Letter

Project Name: Eastern Creek Business Hub – Response to Council Submission - Odour

Reference: 17.1062.L1V3

drawing title PROPOSED SITE PLAN -  
STAGE 1

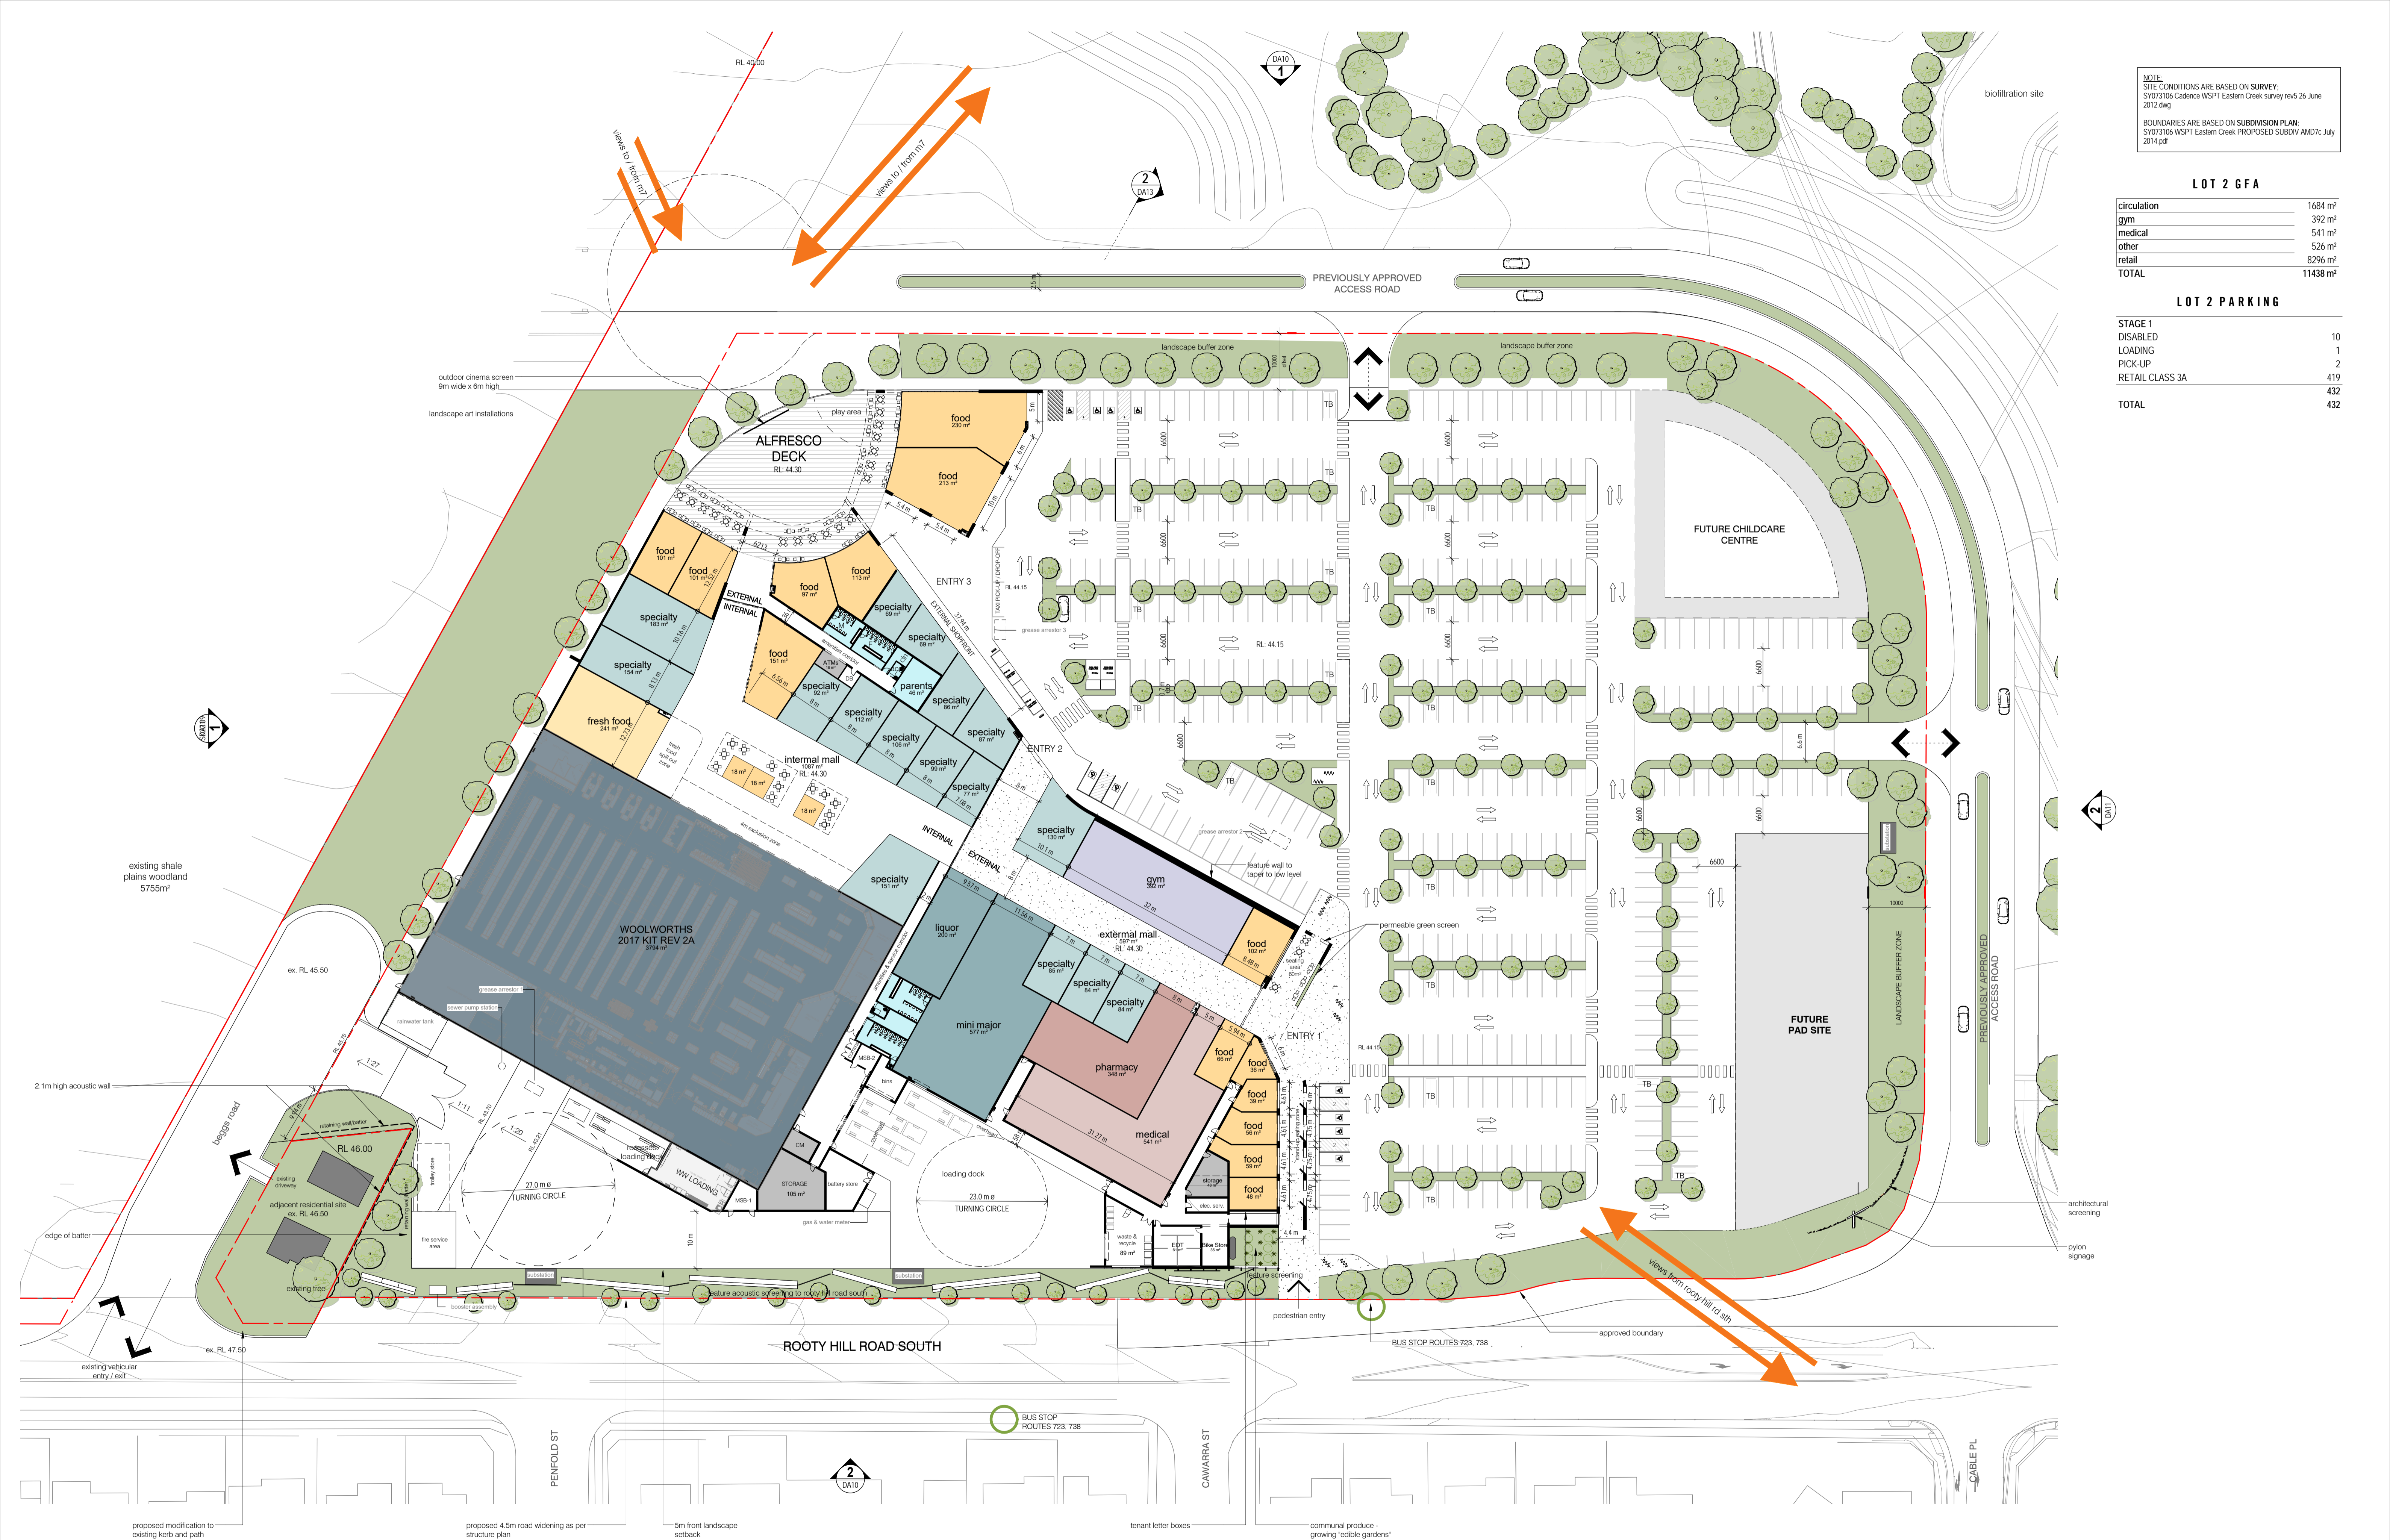
“...The proposed loading dock, however, is not appropriately located for the following reasons:

- a. It is proposed immediately adjacent to the 2 dwellings on the corner of Rooty Hill Road South and Beggs Road, and is located opposite the low density residential area on Rooty Hill Road South. The loading dock activities will therefore impact on the amenity of these nearby dwellings in terms of visual impact, noise and odour.”*

The design of the loading dock and surrounding area is shown in **Figure 1** (highlighted in red). Also shown in **Figure 1** is the area in which the closest dwellings to the loading dock are located (corner of Beggs Road and Rooty Hill Road South, highlighted in yellow). The residences themselves are approximately 15 metres (m) to 20 m from the proposed loading dock. The low density residential area on Rooty Hill Road South, identified in the Council submission is located approximately 65 m to 70 m from the proposed loading dock (not shown in **Figure 1**).

The design of the proposed site includes a height difference of approximately 2.5 m between the loading dock (at approximately RL 44 m) and the adjacent residential site (approximately RL 46.5 m). A retaining wall is also present between the adjacent residential site and the proposed site.

Sufficient capacity in the waste storage area and bins themselves would be required to be provided by the supermarket operator and the waste collection schedule will need to be managed to ensure that lids on bins are able to be closed at all times (i.e. no odorous waste will be stored external to a lidded bin). Where liquid residues (i.e. leachate) is present at the internal base of the putrescible waste bins, this should be transferred to the waste collection vehicle and managed offsite, and where any residual leachate remains or has leaked during collection this should be washed down immediately. Bins should also be cleaned on a regular basis (at a minimum of a weekly frequency) to ensure that any leachate or residual food scraps are removed from the bins and waste storage area.

On the basis of the information presented within this report, it is concluded that the risk of unacceptable odour impacts being experienced at the nearest residential receptors is low, and is essentially manageable through the waste collection contract.
